Ribble Valley Borough Council

## DELEGATED ITEM FILE REPORT - APPROVAL

3/2014/0957/P

Roof cover over existing slurry store and extension of that slurry store at Wharf Farm, Talbot Street, Chipping PR3 2QE

PROPOSED PLAN

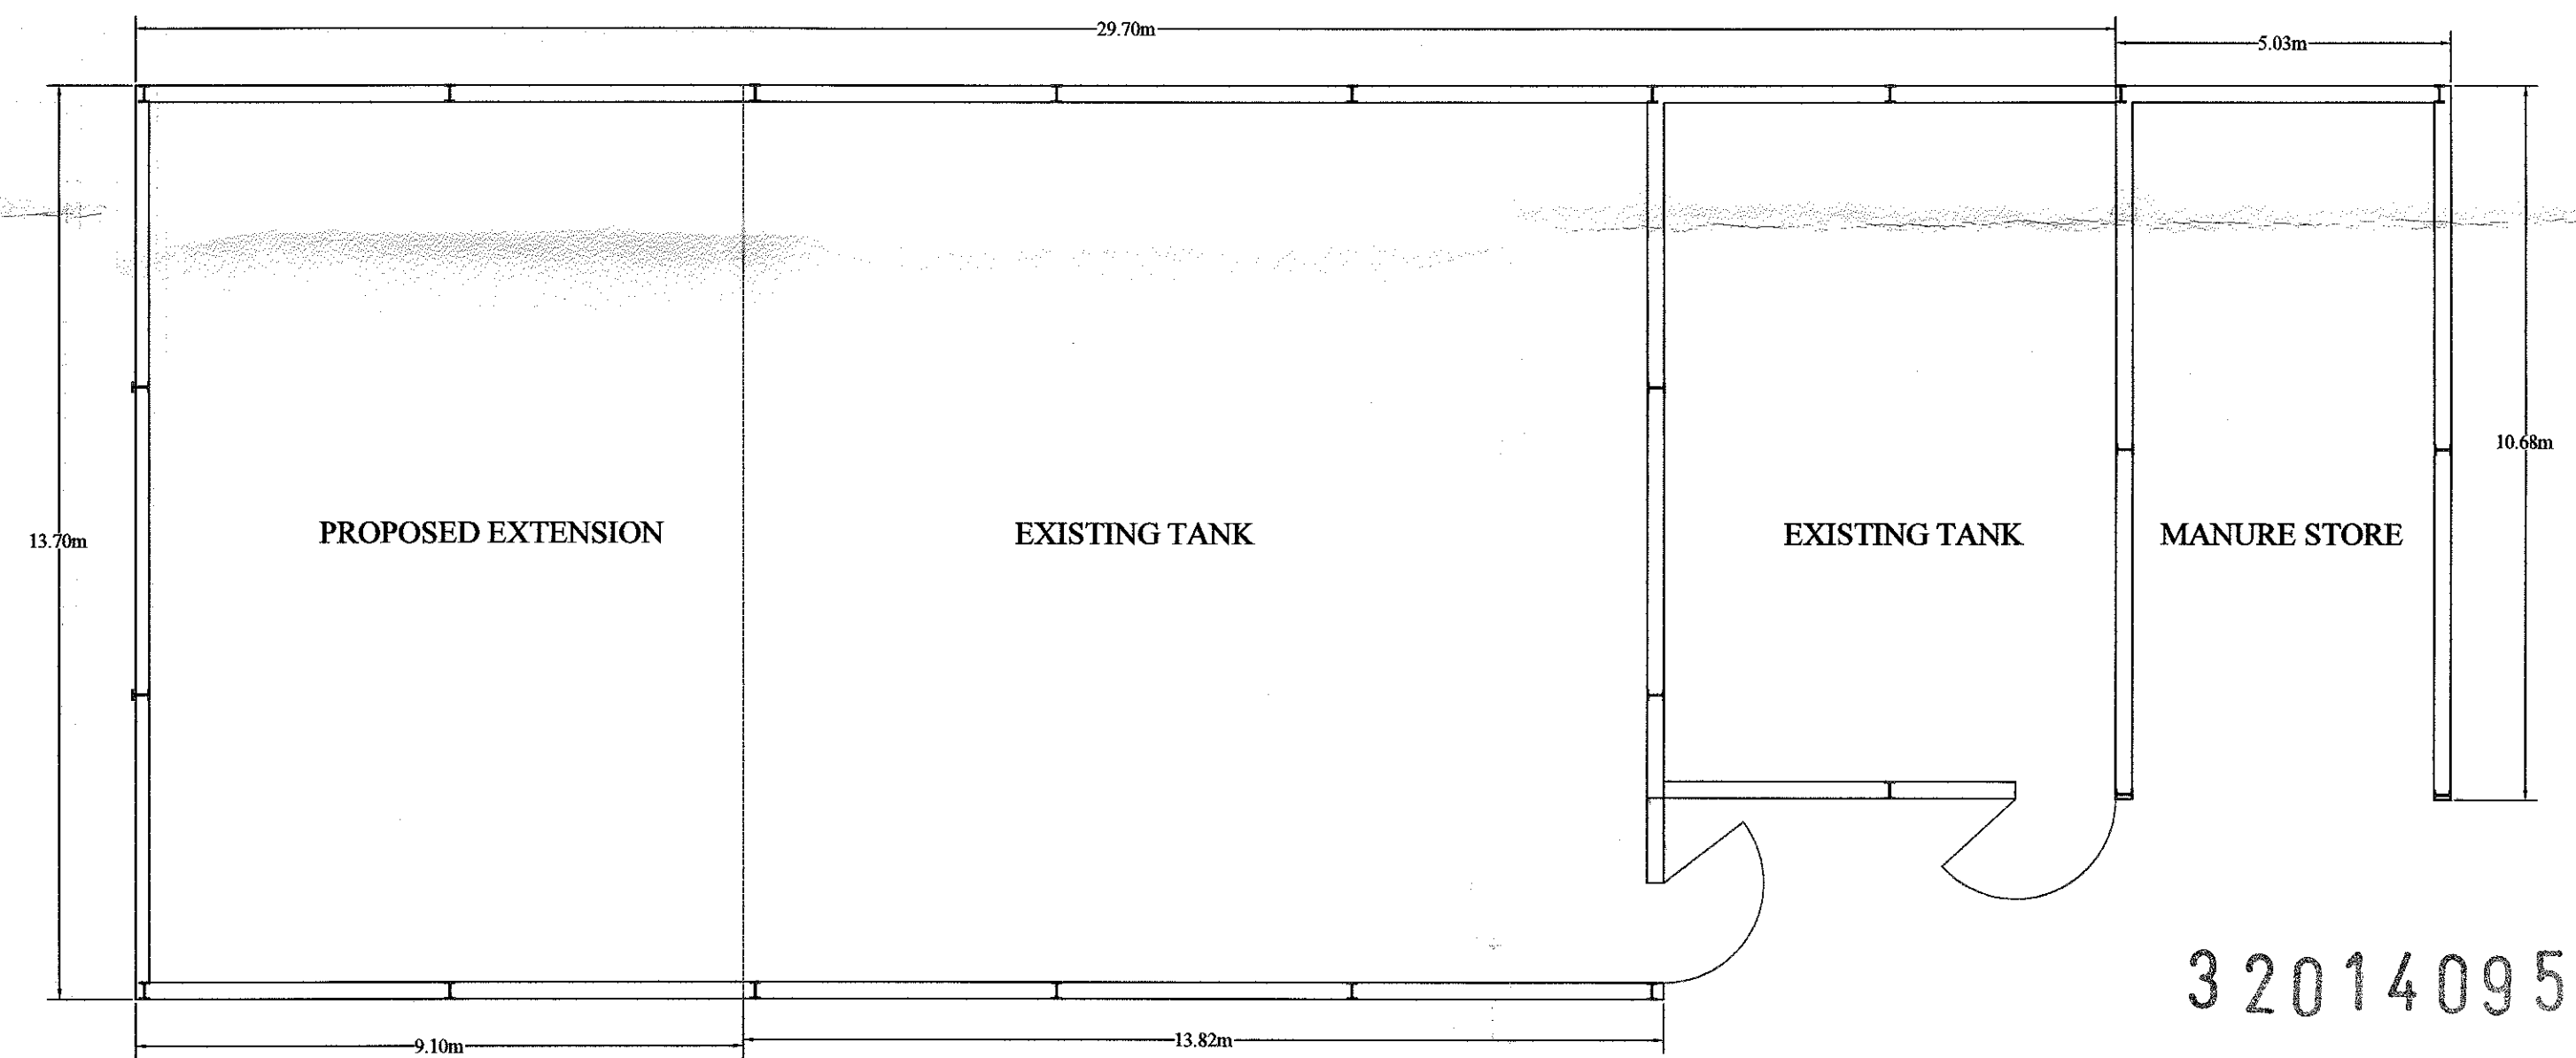
concerned that natural grey roofing sheets are proposed on this low level building in such close proximity to the main road would look visually prominent unnecessarily. The stone farmhouse and barn have traditional stone slate roofs, a lower agricultural building has slate blue coloured roofing sheets whereas the taller of the modern agricultural buildings all have natural grey colour roofing sheets. Whilst the agent has said the natural grey coloured roofing sheets compliment the sky, given the low level nature of the roof on the slurry store, I consider this will not be applicable here as the building will be seen against existing buildings. A darker roof colour will blend with the existing low level on site and will complement the timber hit and miss boarding on the existing buildings and the proposed building and be less reflective against sunlight/ daylight. The agent has agreed to use a darker roofing material and therefore a condition will be used to secure this.

An existing roadside hedge is present which shield the existing concrete panel/ block base walls from the main road. It is important that should this hedge die as a result of the proposed 10m extension, and the works needed to roof over the existing slurry store, that a replacement hedge be planted along the whole length. This is to ensure that the rural character of the AONB on the entrance to Chipping is not compromised by the addition of this building.
